Our Ref: AW/335/19/HH

**Town & Country Planning Act 1990 (as amended)
Town & Country Planning (Development Management Procedure) (England) Order 2015
Application for Planning Permission for Works or Extension to a Dwelling**

Development Single storey side extension and extension to existing garage

Location 18 Gunwin Court Aldwick

Drawing title
Proposed Site Plan / Block Plan

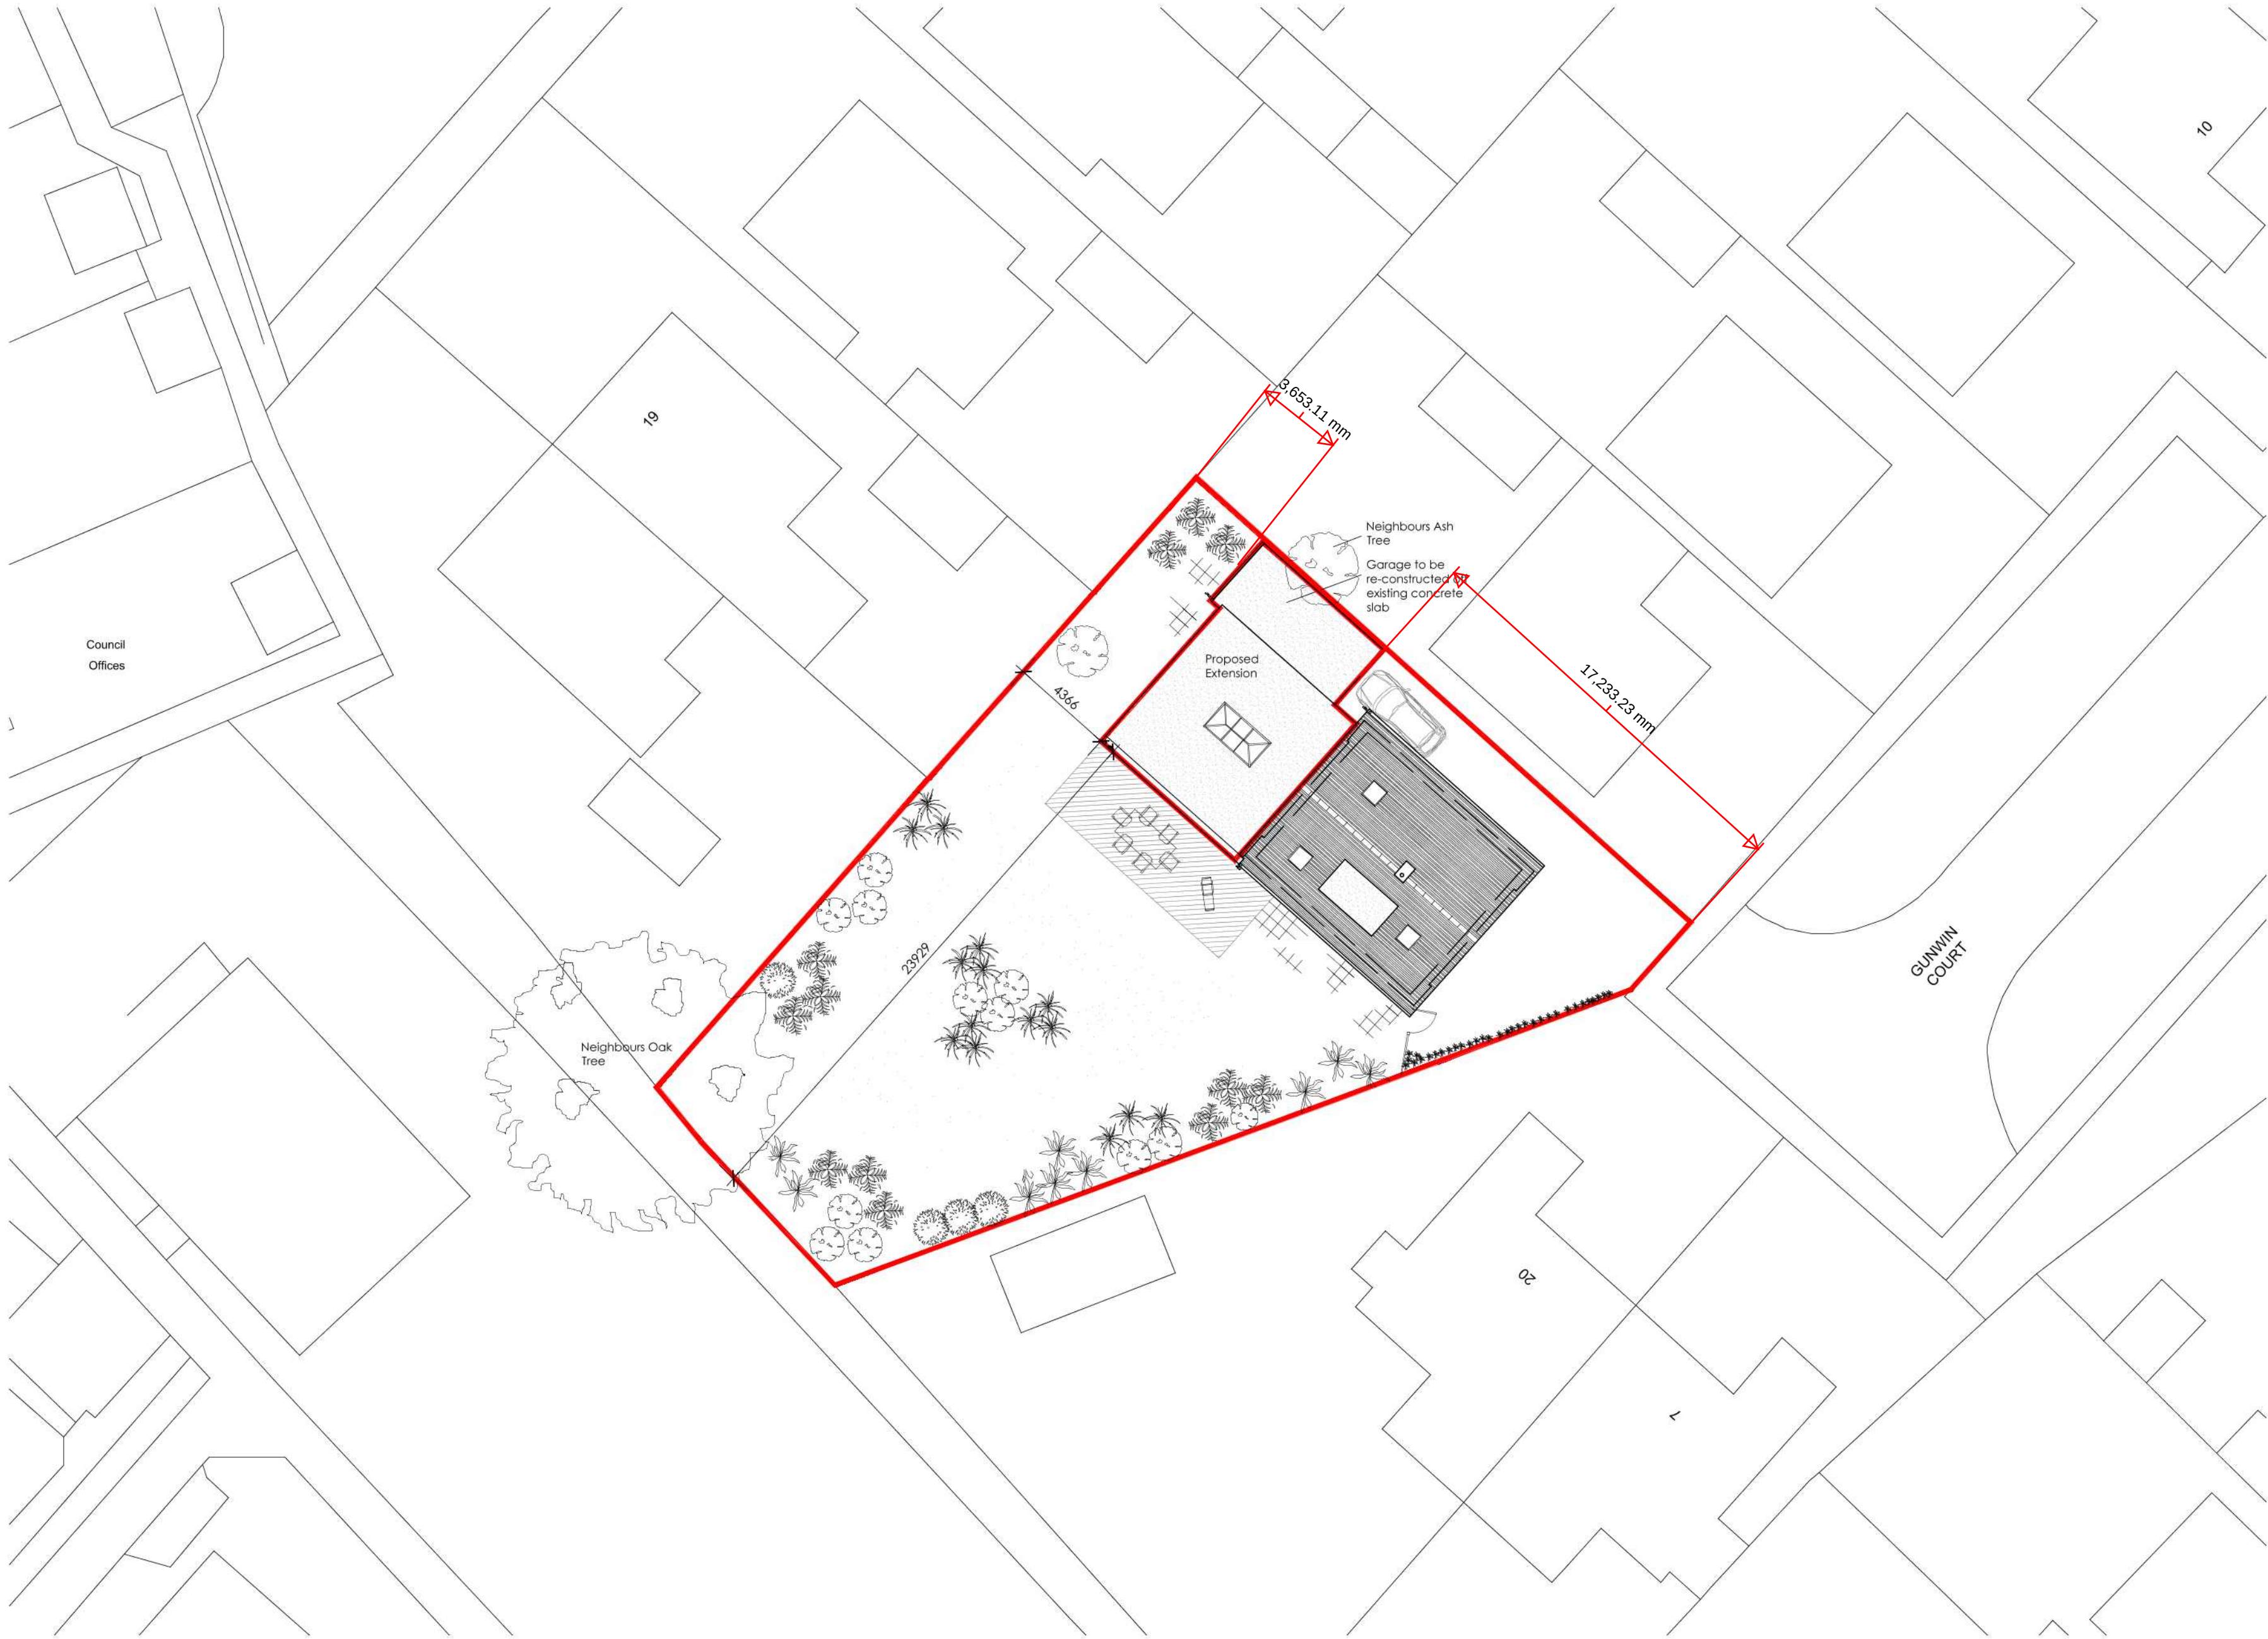
Block Plan: You are required to include a dimension from the garage to all site boundaries.

As requested please find attached a revised block plan giving additional dimensions from the garage.
